From: Caitlin Cameron
To: Donaldson, Helen
CC: Andrews, Deb
Date: 10/26/2015 5:46 PM
Subject: Proposed Hotel - preliminary design comments

Below are preliminary comments in reference to the Multiple-family Design Standards and Design Guidelines for the Eastern Waterfront. Floor plans would be helpful for further review.

**SITE PLAN**

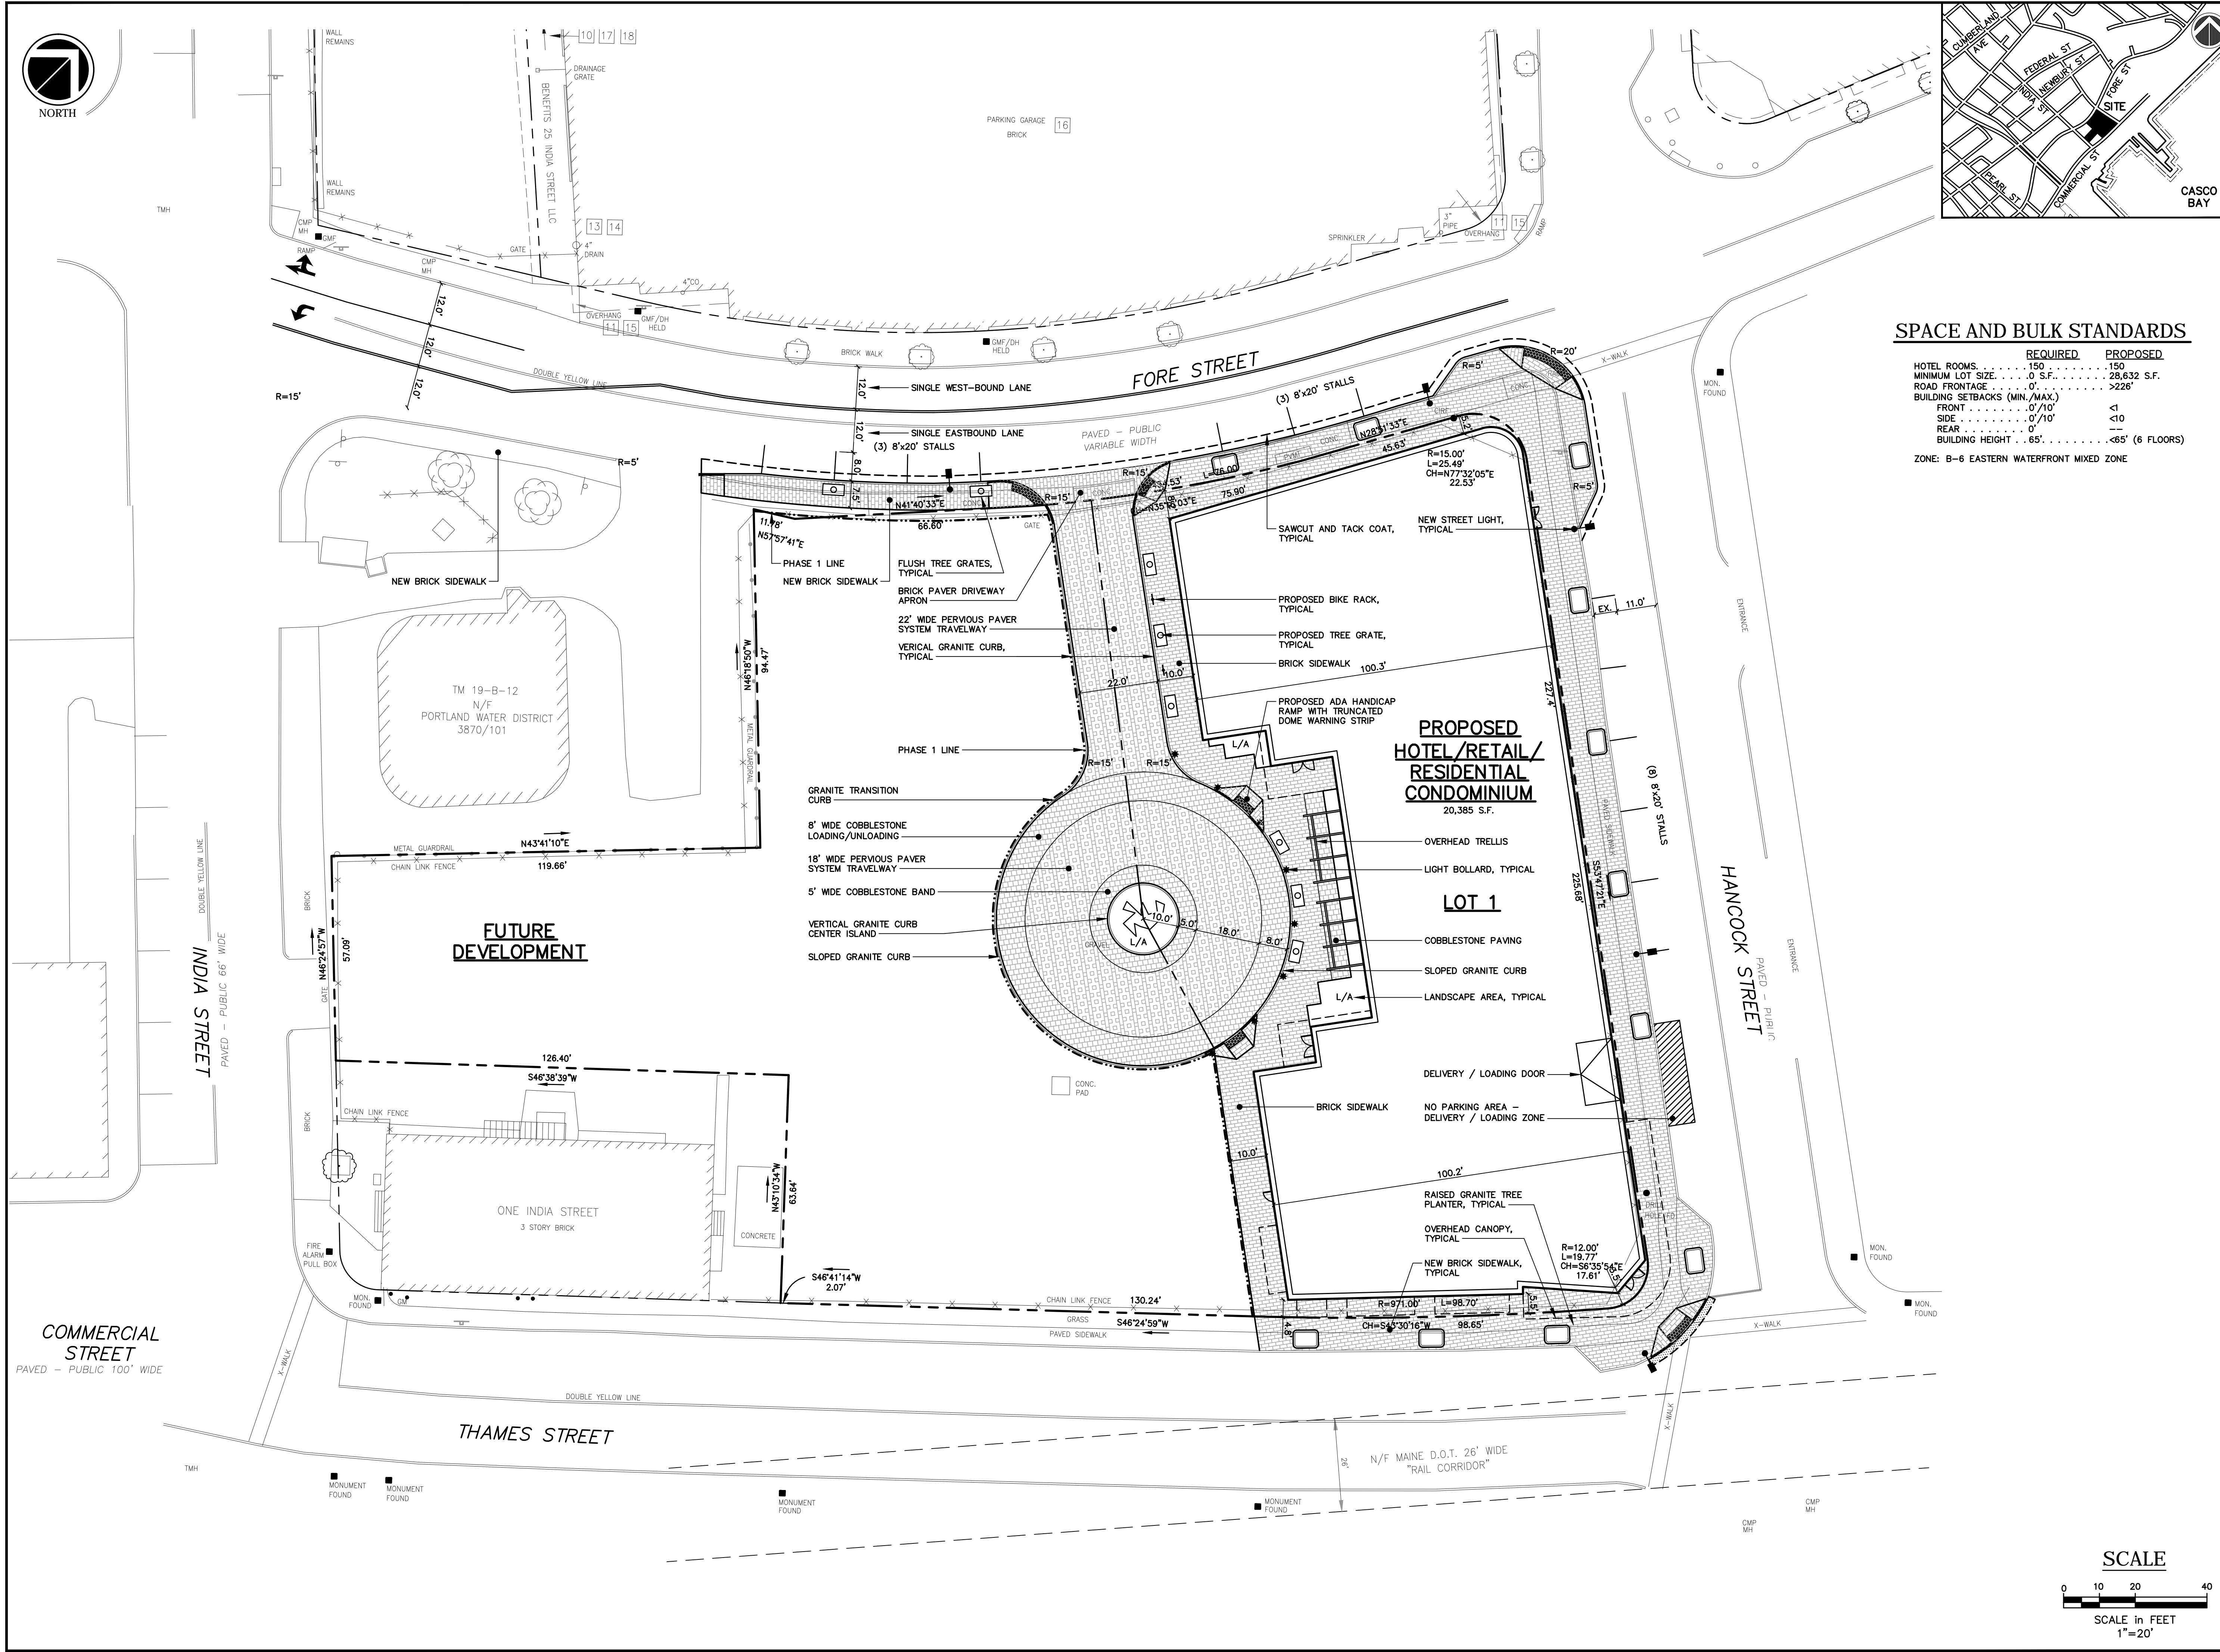
- Because there are not many buildings surrounding the site to provide an architectural context, the design aspects of the project we are most focused on include building orientation and circulation, as well as visual impact as a gateway along the waterfront.

- Orientation of corner treatments: Emphasis and legibility of building entrances is a key principle of concern for any urban project. If the primary entrances to both the hotel and the residential units will be interior to the block, then the reviewers agree that emphasis and special treatment should be on the building corner on Fore Street interior to the block, rather than the Hancock/Fore corner. Emphasis and visual cues oriented to the building approaches (from Commercial Street and from downtown direction) provide legibility about where to enter the building.
